**Application Reference:** 2026/0060

**Site Address:** 25 Cranston Close, Monk Bretton, Barnsley, S71 2LB

**Introduction:** Erection of 2 storey side extension to dwelling.

Drawing Title  
**PROPOSED PLANS**

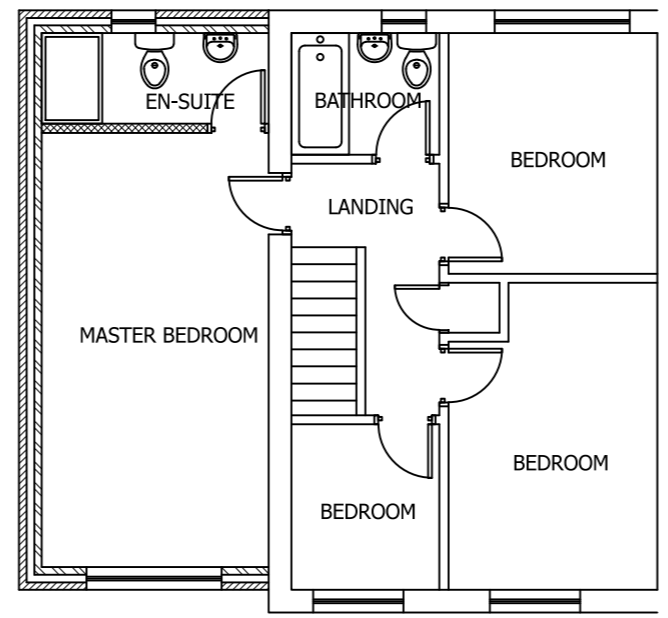
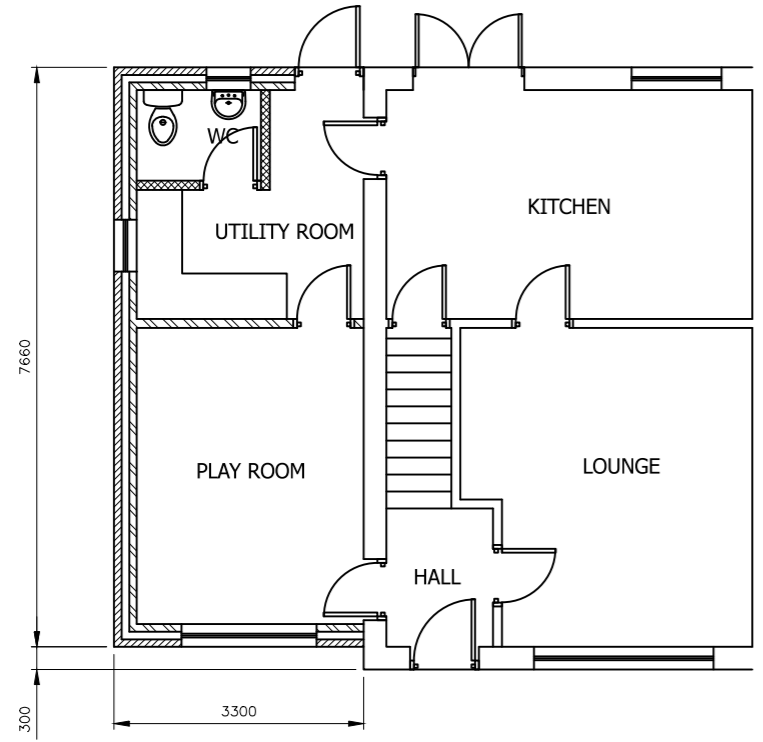
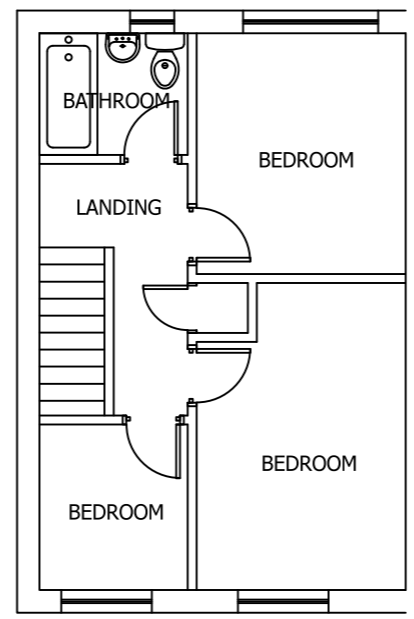
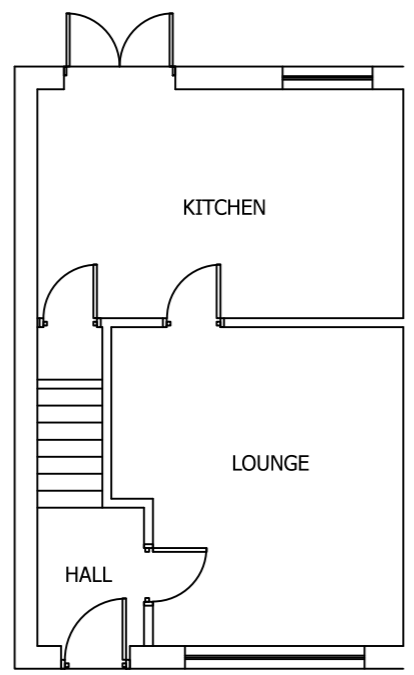
The glazing proposed to the ground floor and first floor rear elevation window is detailed to service a W/C and an en-suite. These windows shall be conditioned to be obscured glazing to protect the residential amenity of the applicant and neighbours to the north of the proposal.

The proposal would increase the number of bedrooms on site from 3 bedroom to 4 bedrooms. Given the proposal currently provide parking facility for 3 bedrooms, the parking facility is also considered satisfactory for a 4 bedroom property

- 3) The external materials shall match those used in the existing building.  
**Reason: In the interests of the visual amenities of the locality and in accordance with Local Plan Policy D1 High Quality Design and Place Making.**
- 4) The ground floor and first floor rear elevation windows servicing a W/C and an en-suite shall be of obscured glazing with an obscurity rating of no less than 4 in the Pilkington Glass Range (or an equivalent obscurity rating). The glazing shall be retained as such thereafter.  
**Reason: In order to safeguard amenities of the applicant and of the occupiers of the dwelling to the northwest in accordance with Local Plan Policy GD1 General Development.**

Drawing Title
PROPOSED ELEVATIONS

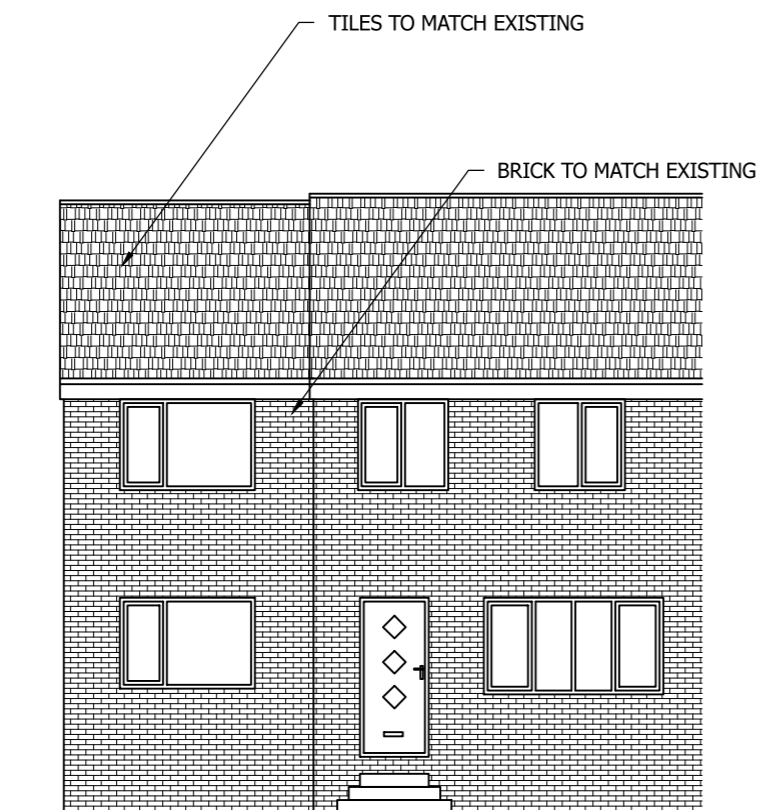
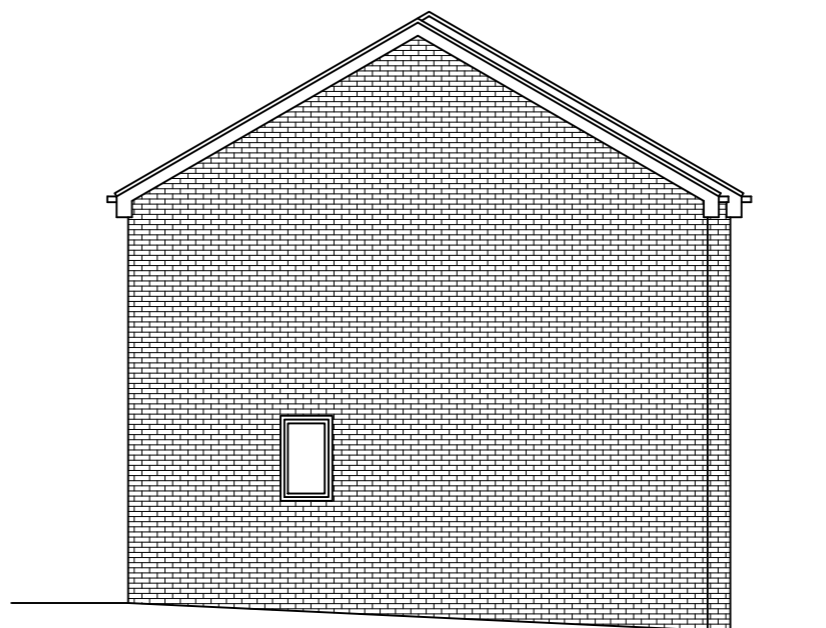
The proposed extension provides an acceptable sideways projection, less than two thirds the width of the existing dwelling. The side extension is set back from the existing front elevation of the dwelling and down from the existing ridge. This allows the proposal to

remain subordinate to the existing dwelling. A pitched roof form is proposed which is in keeping with the character of the dwelling and street scene. The proposed glazing to the front and rear elevation is of a similar scale to the existing fenestration. The use of matching materials is to the proposals benefit and allows the proposal to remain in keeping with the site.

It has been necessary to make contact with the applicant to make an amendment for the removal of the first floor side elevation windows in order to prevent any opportunity for overlooking the residential amenity space of neighbours to the west.
